DECISION DELEGATED TO DEVELOPMENT MANAGER

Application No: H22-0070-19 **Applicant:** Seagate Homes (UK) Ltd

Proposal: Details of external materials, design and position of external boxes, gas flues and soil vent pipes, boundary treatment and Management Plan for Public Open Space (Conditions 4, 5, 7 and 8 of H22-0202-16)

Location: Land Off Dean Close/Small Drove Weston Spalding

Rear Elevation

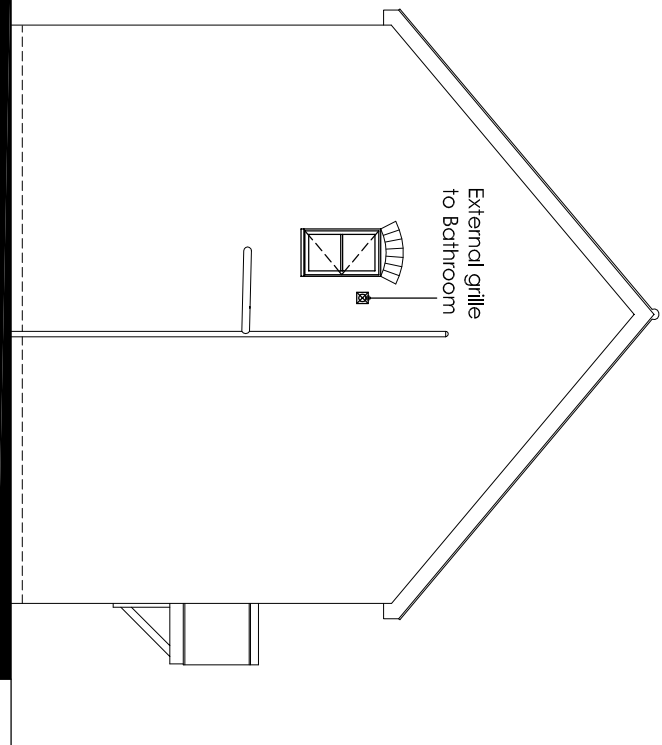
Amended elevation plans were requested to address the concern that a large number of meter boxes were on the front elevation of properties. These have been repositioned on side elevations where practicable or replaced with ground mounted boxes.

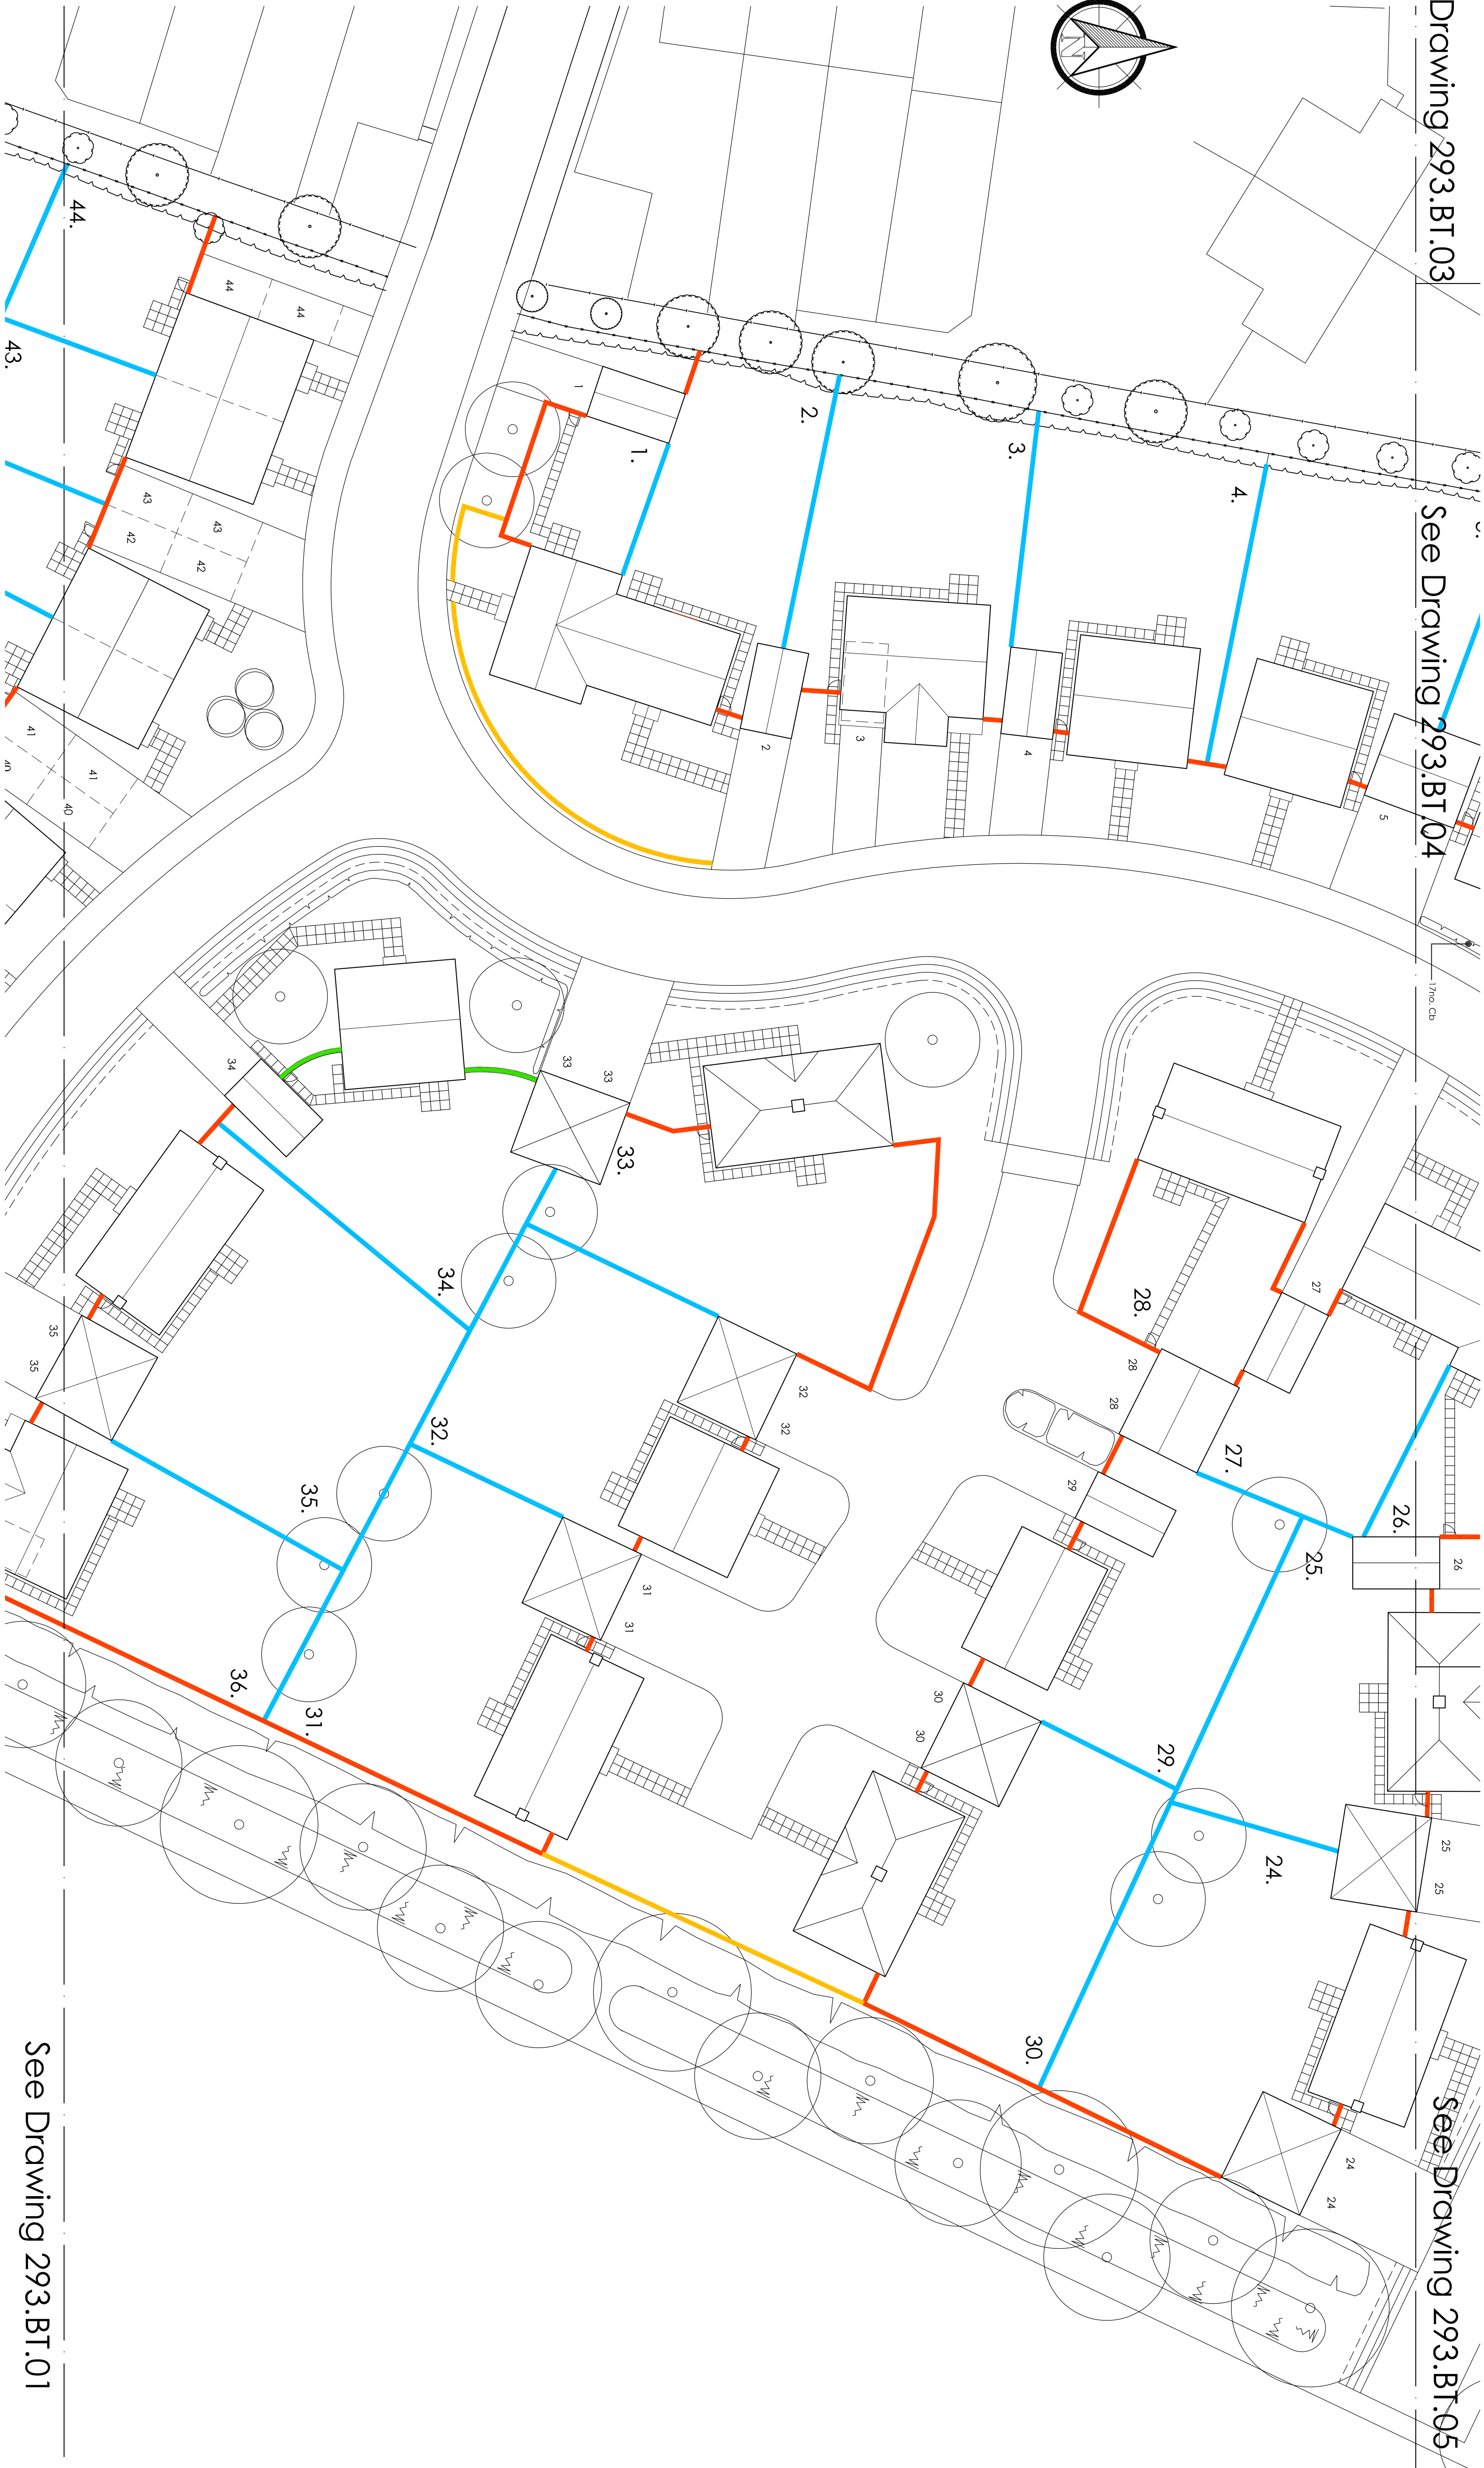
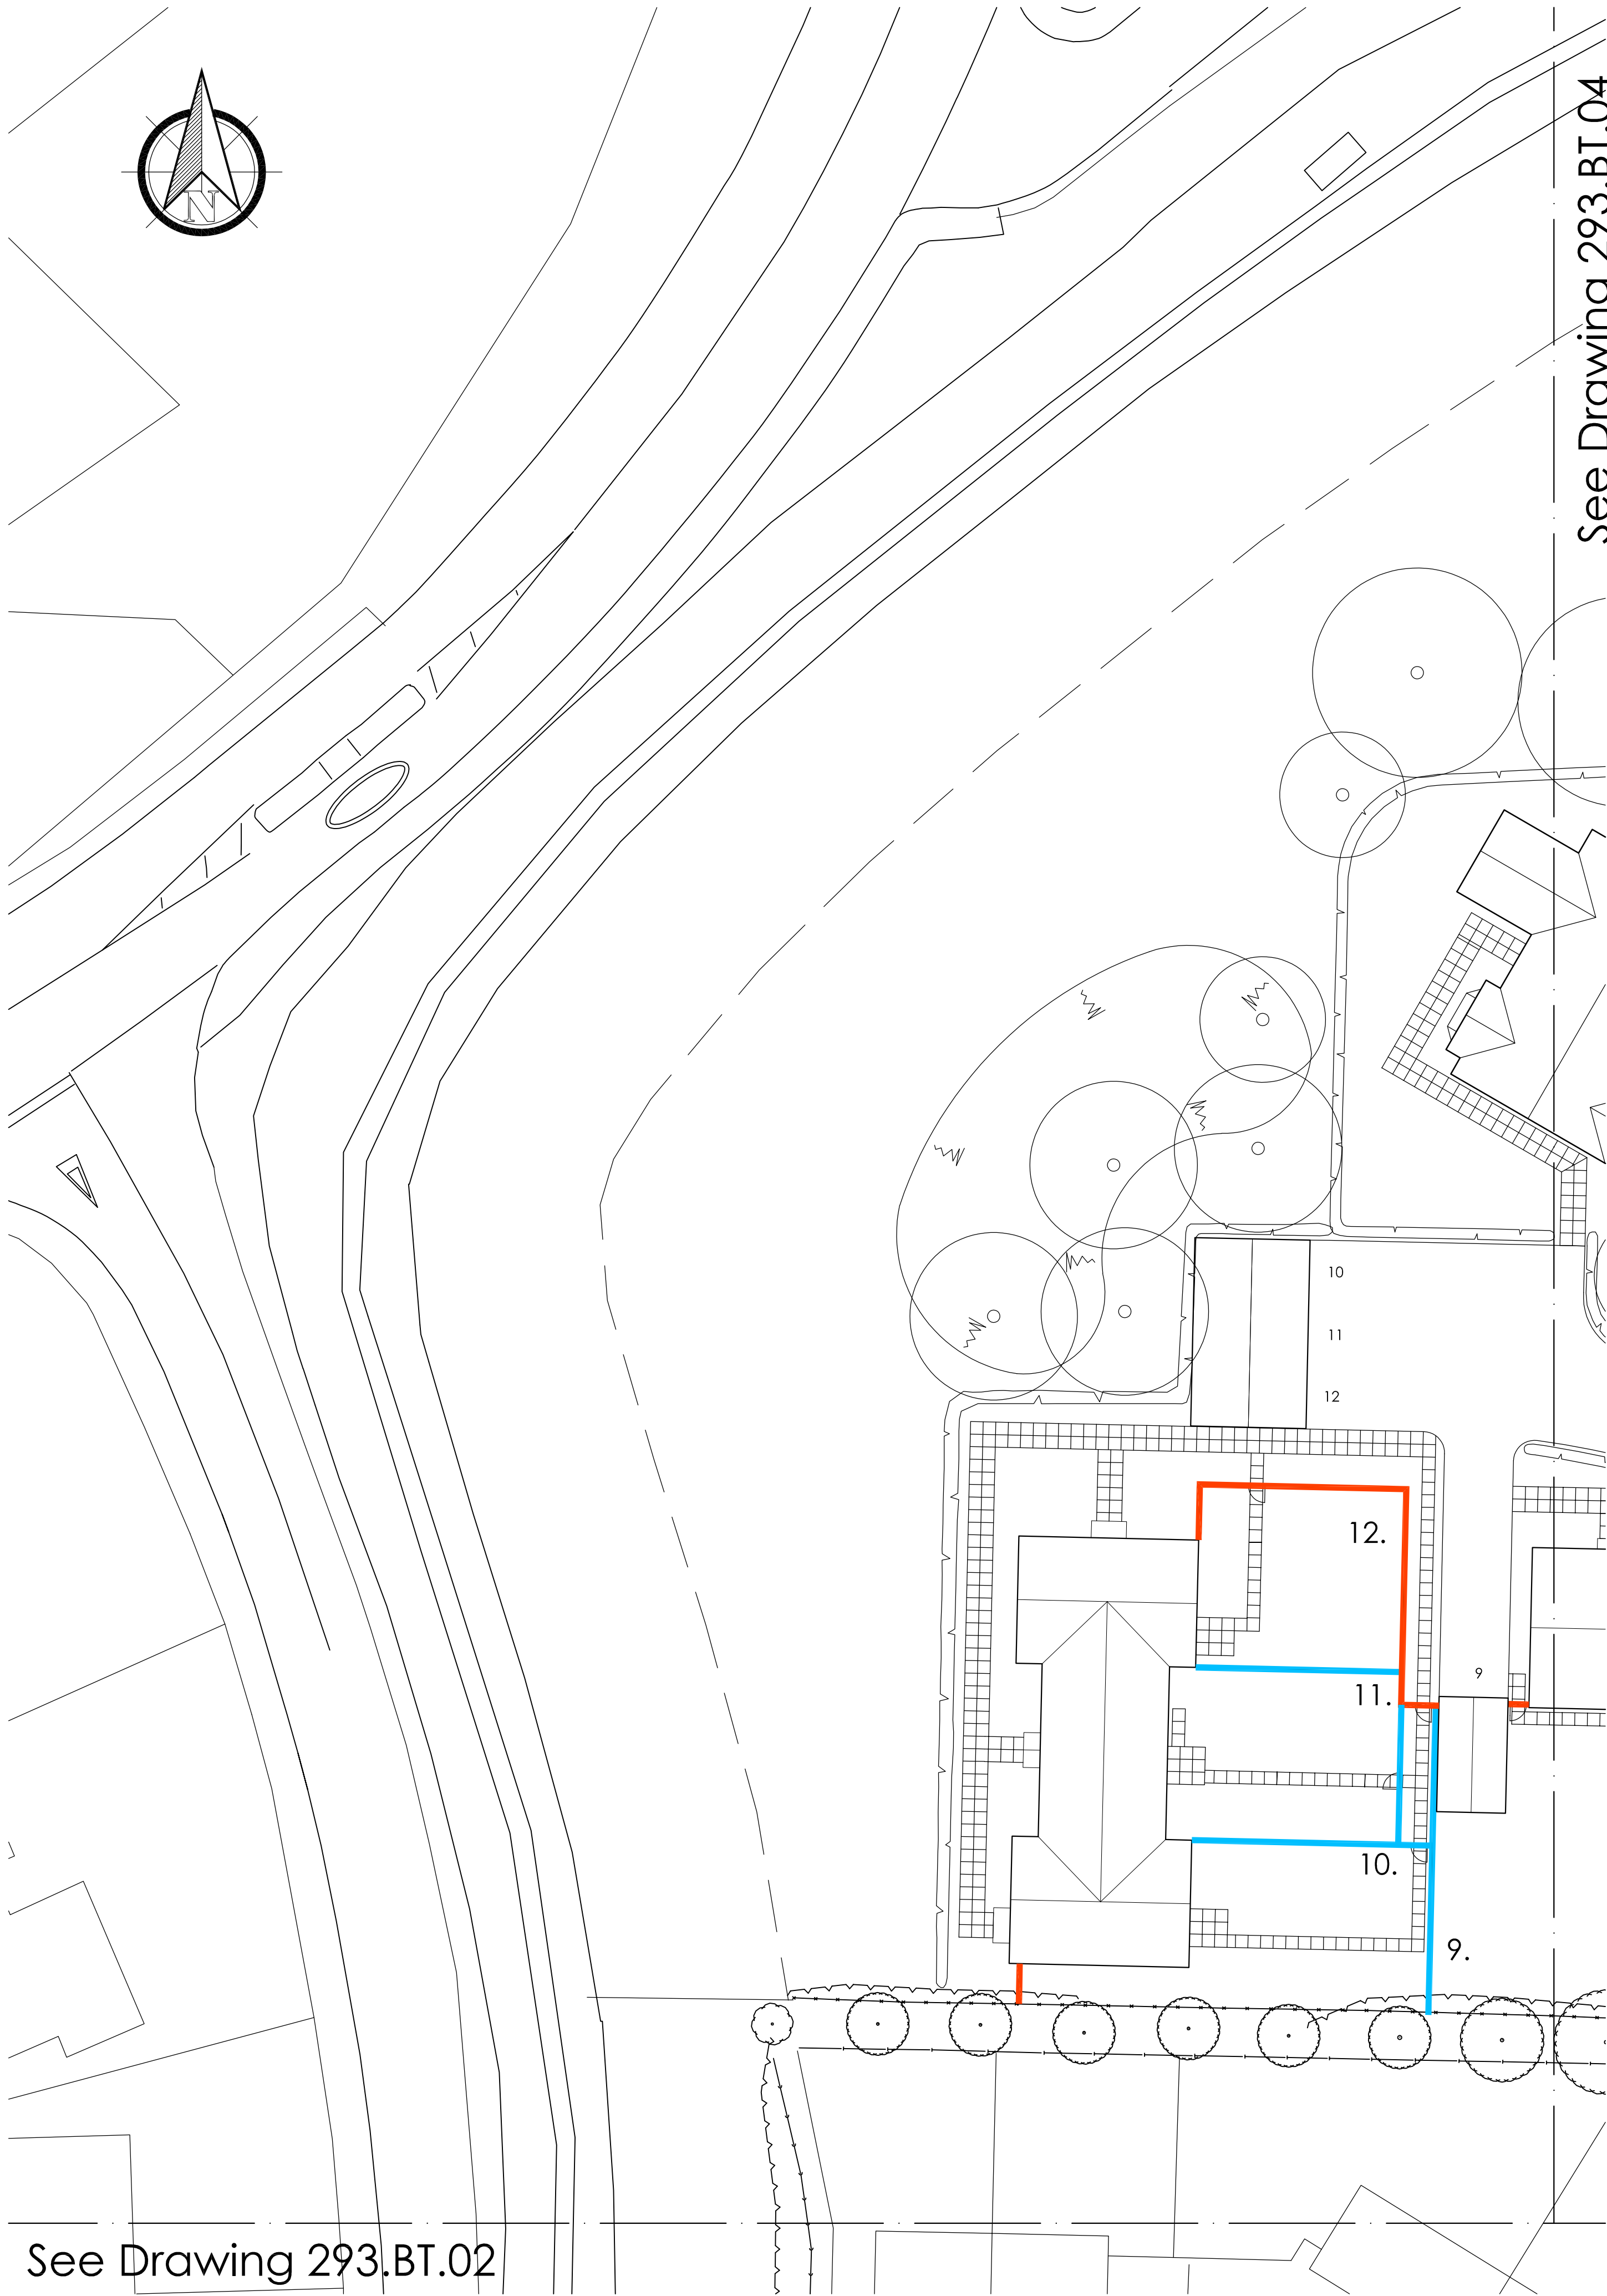
Boundary treatments are proposed to comprise predominantly of 1.8m close board fencing and 1.8m timber panel fencing.
